**Consultation Response from KC, Highways Development Management (HDM)**

**2022/92471 Heckmondwike Hub Bus Station, Royle Fold, Heckmondwike, WF16 0HW**

**Redevelopment of Heckmondwike Bus Station including a new concourse building with waiting room, Changing Places WC, driver offices, 6 No. bus stands, landscaping, and associated works**

**RECOMMENDATION: Further information required**

## **SWEPT PATH ANALYSIS**

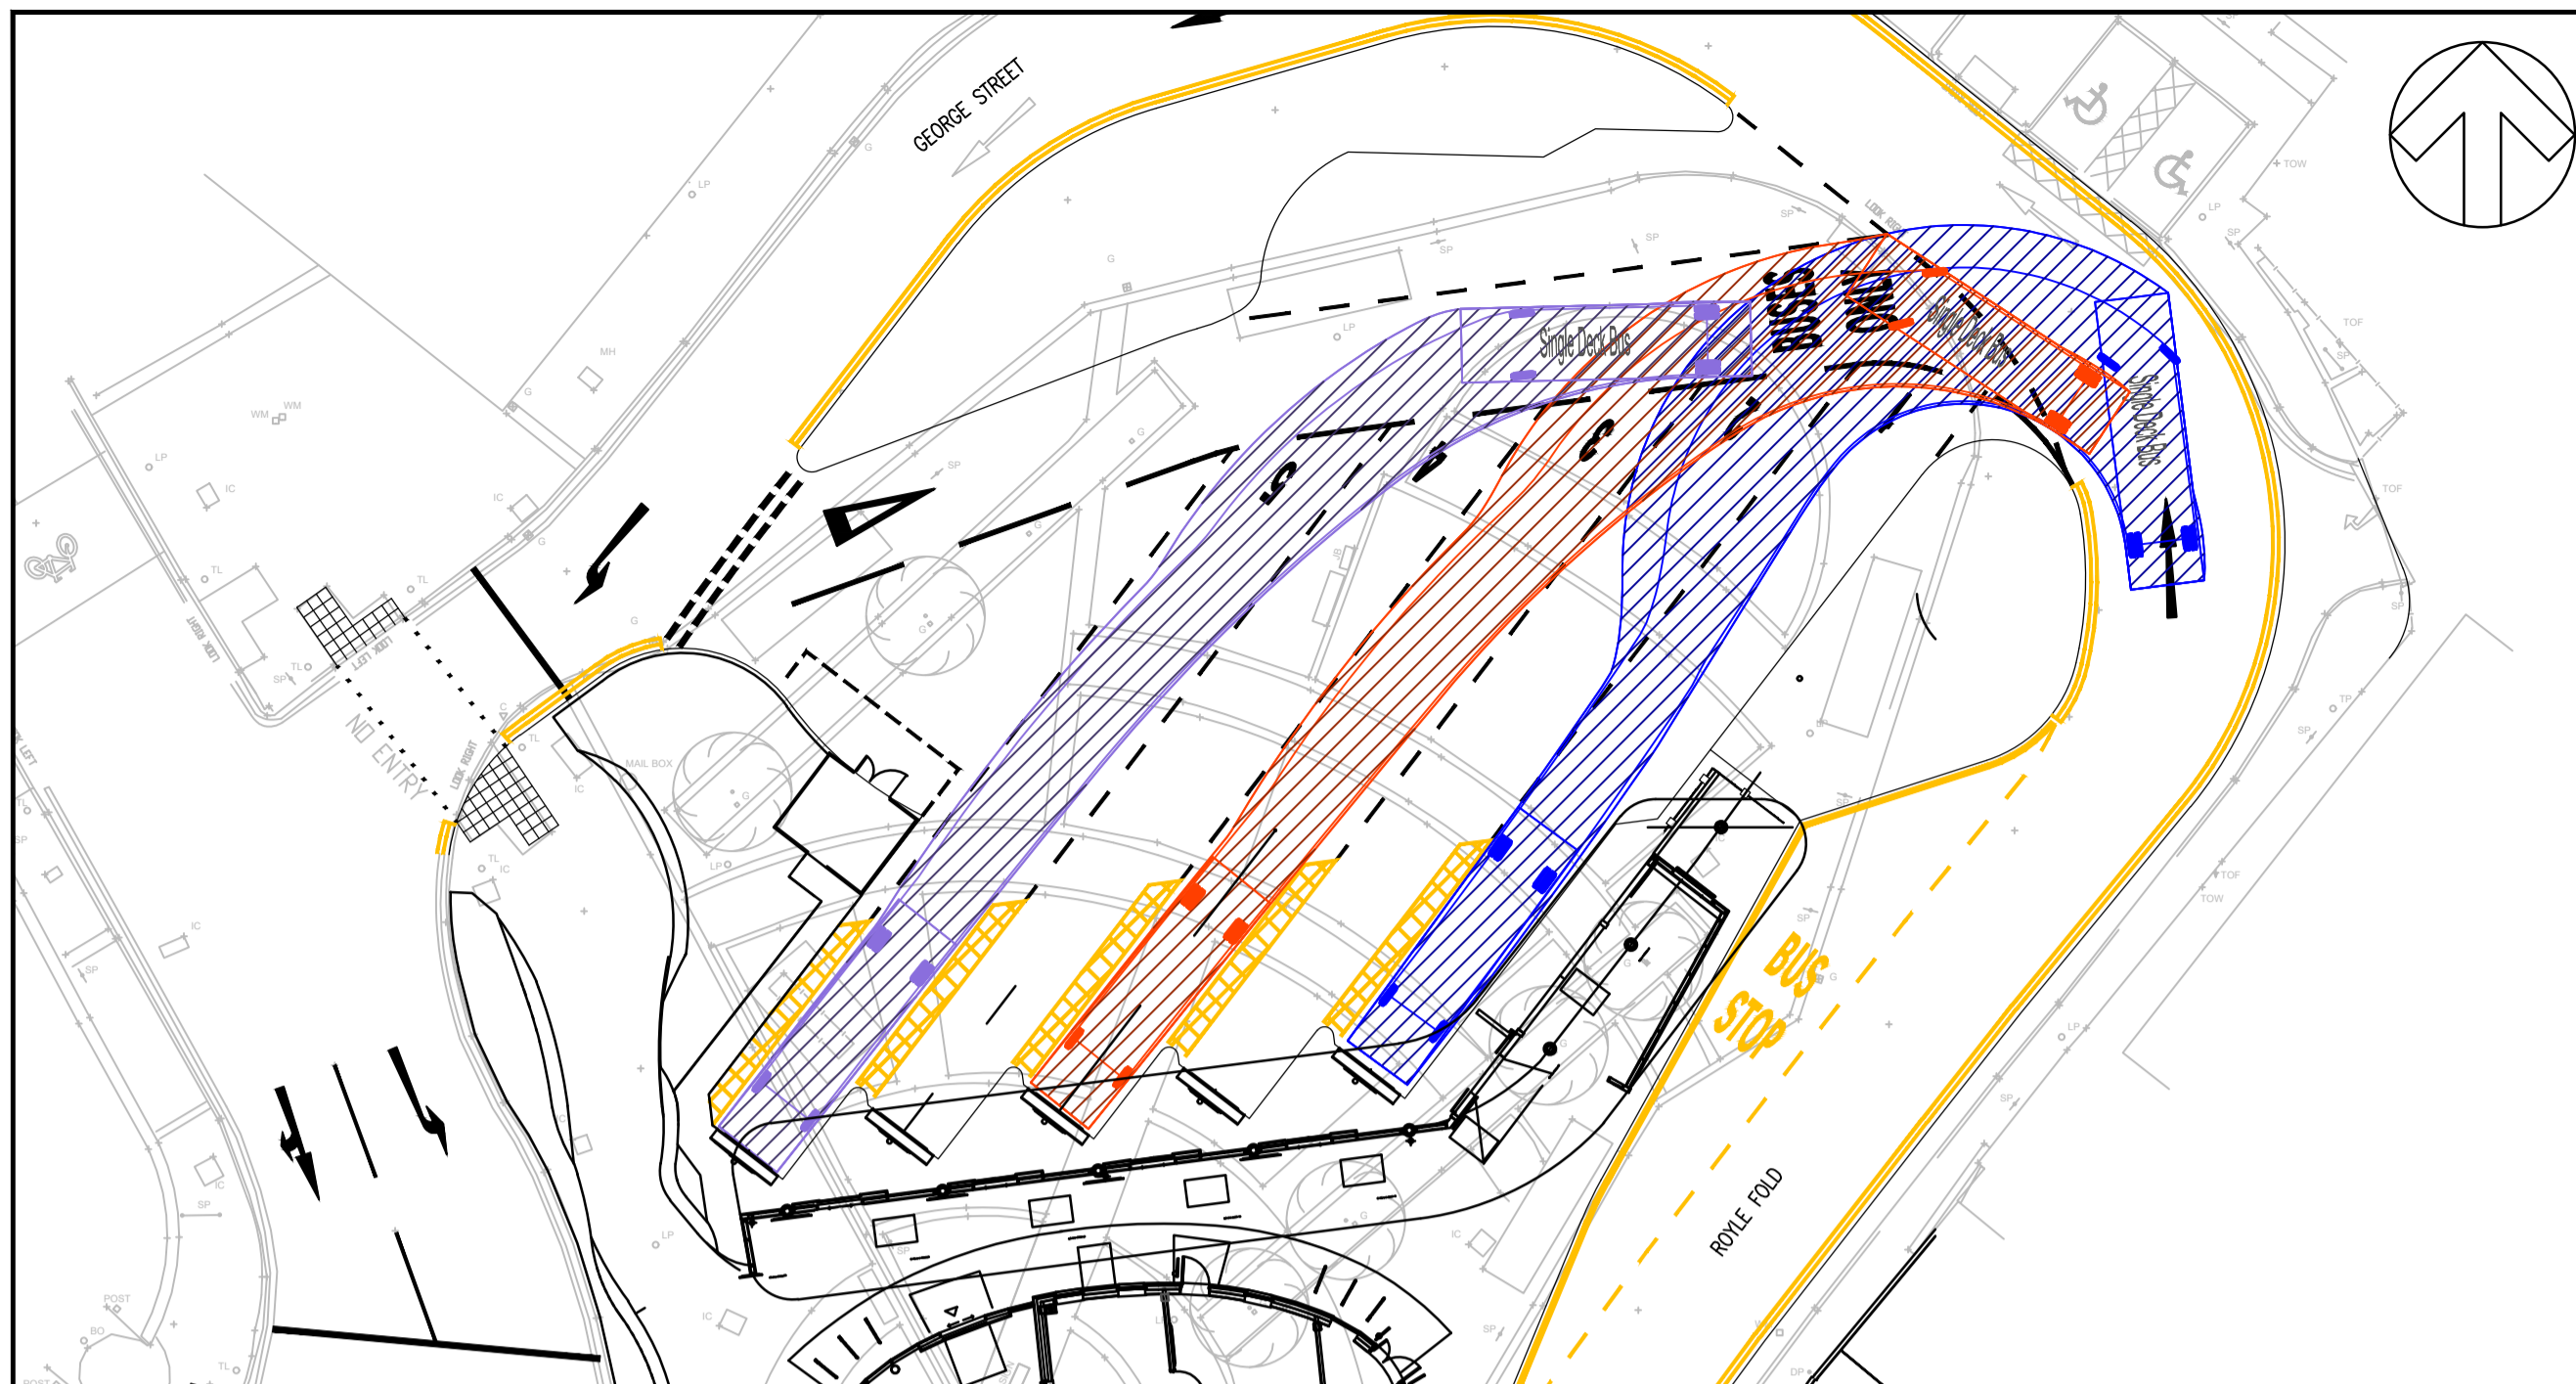
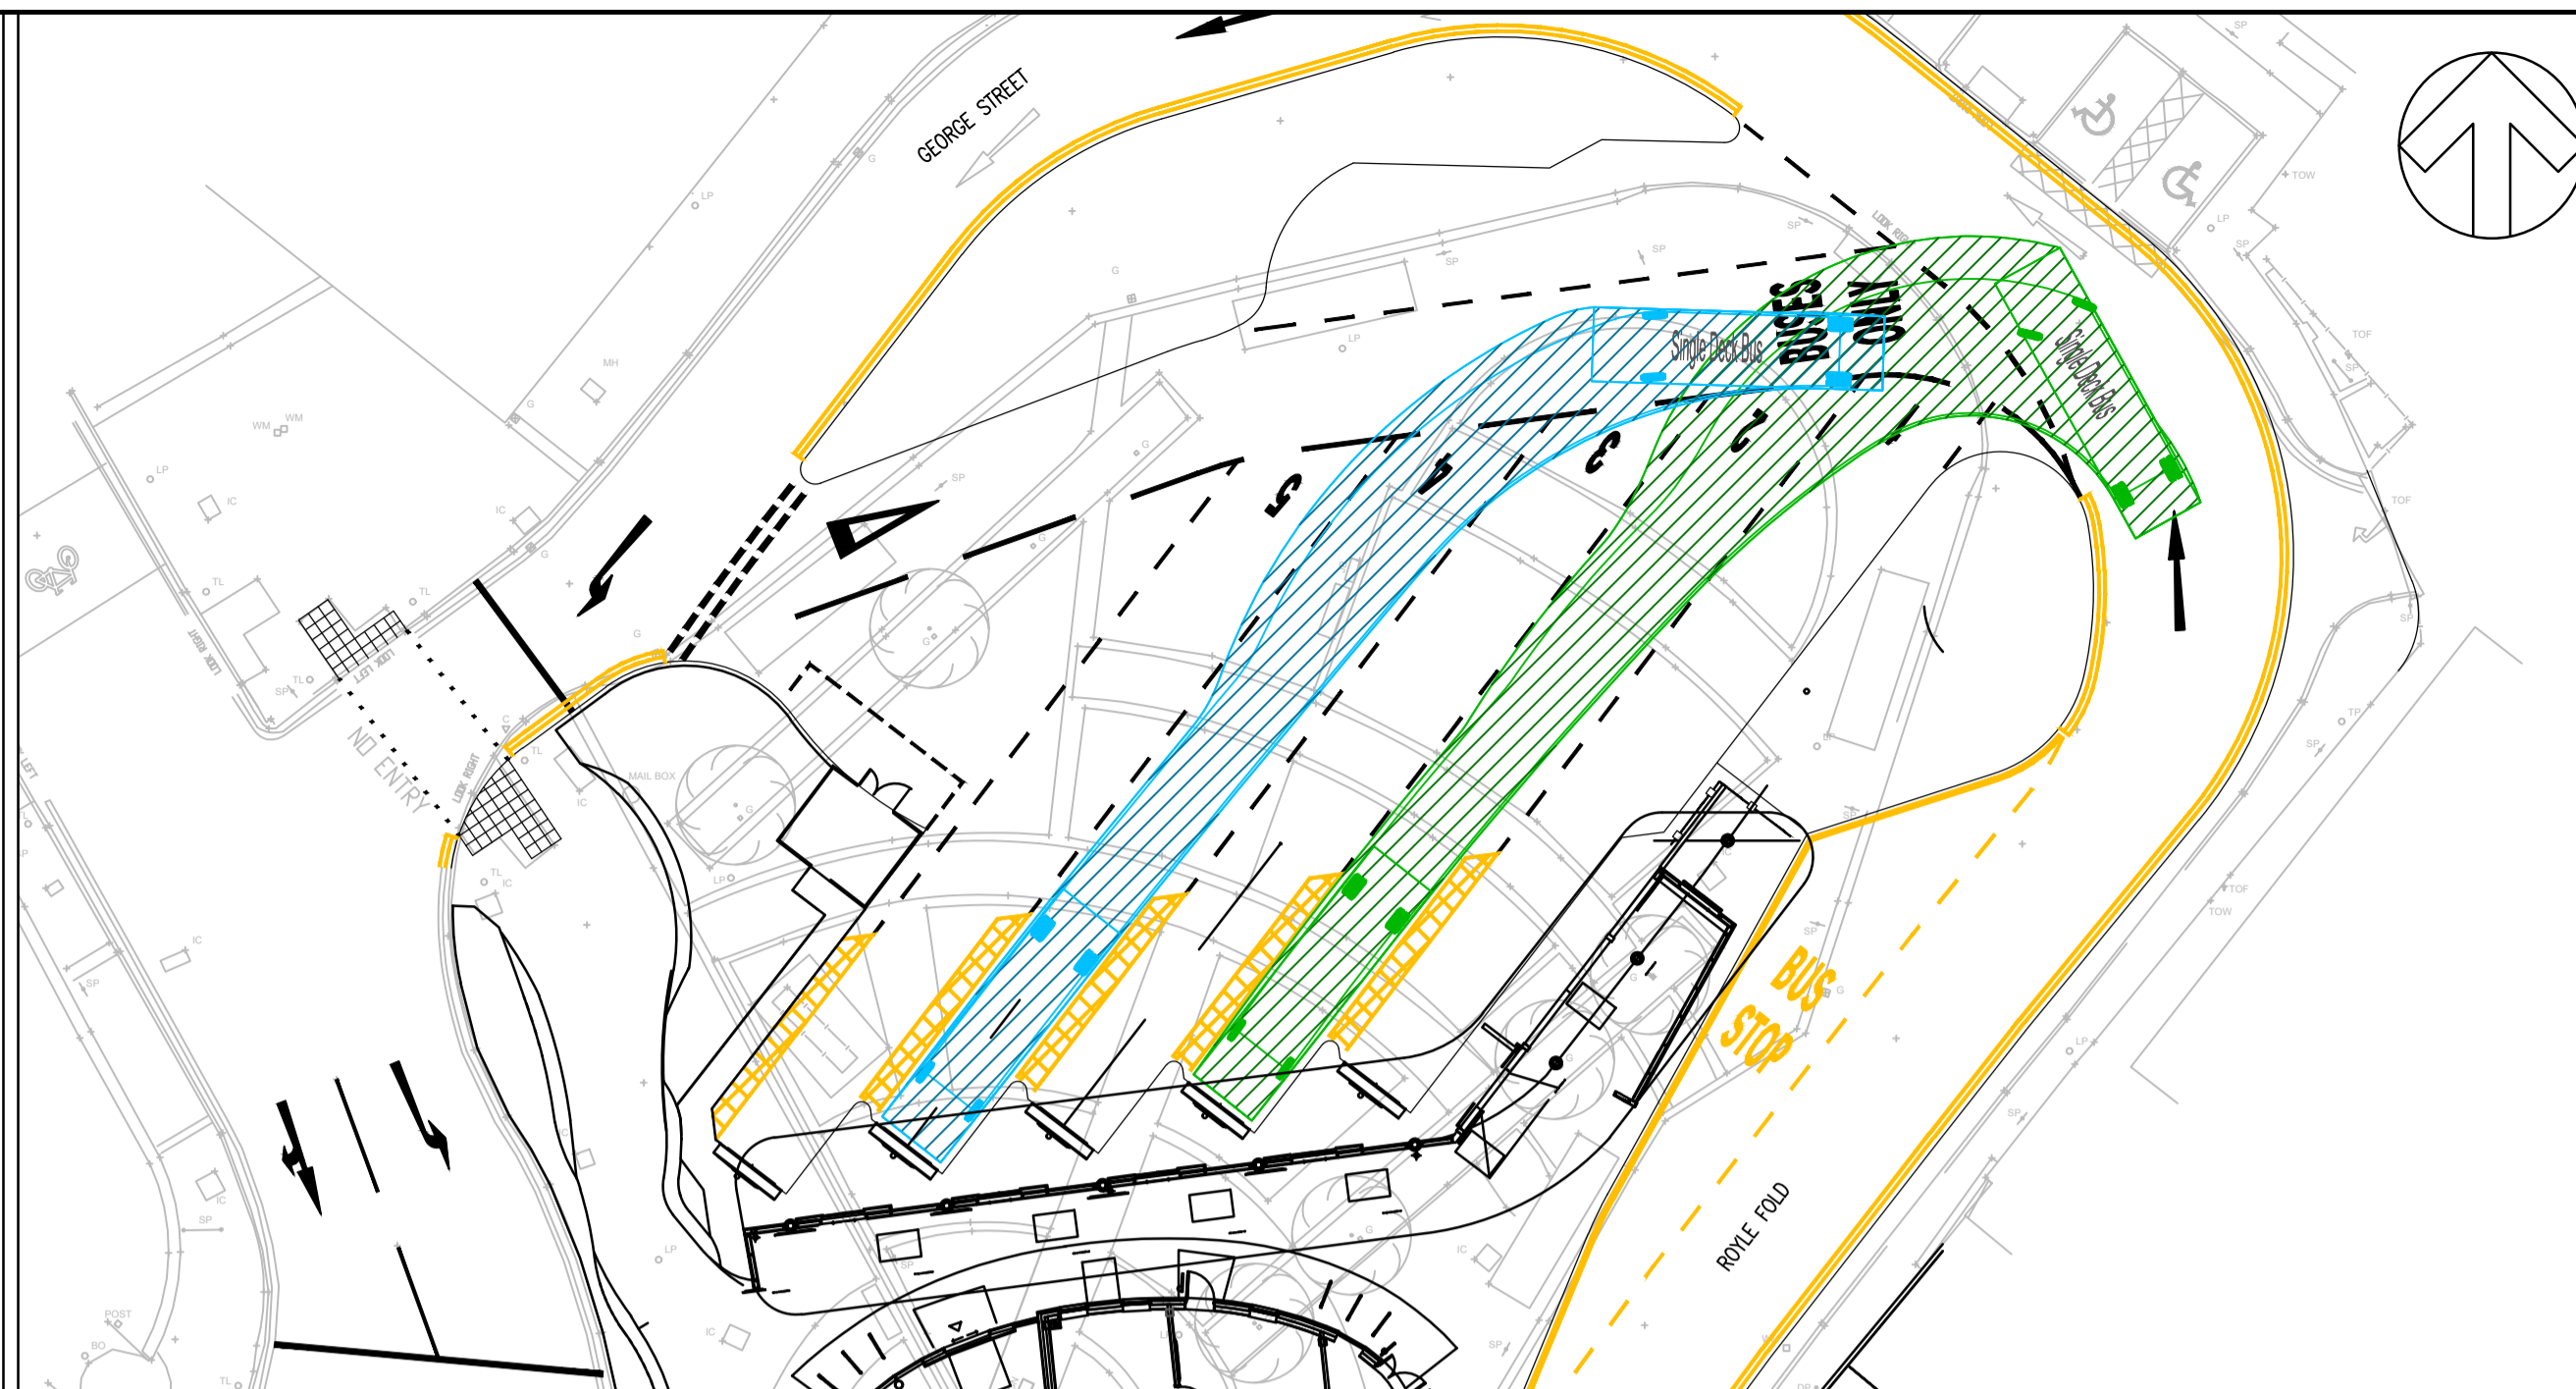
The Transport Assessment includes swept path analysis (SPA) for proposed bus stands 1-5 that generally appears to be acceptable. However, no SPA has been provided for bus stand 6, the layover bay, the bin store bay or the dentist access. Therefore, it is unclear whether these facilities will be able to operate safely and effectively, with specific concerns as follows:
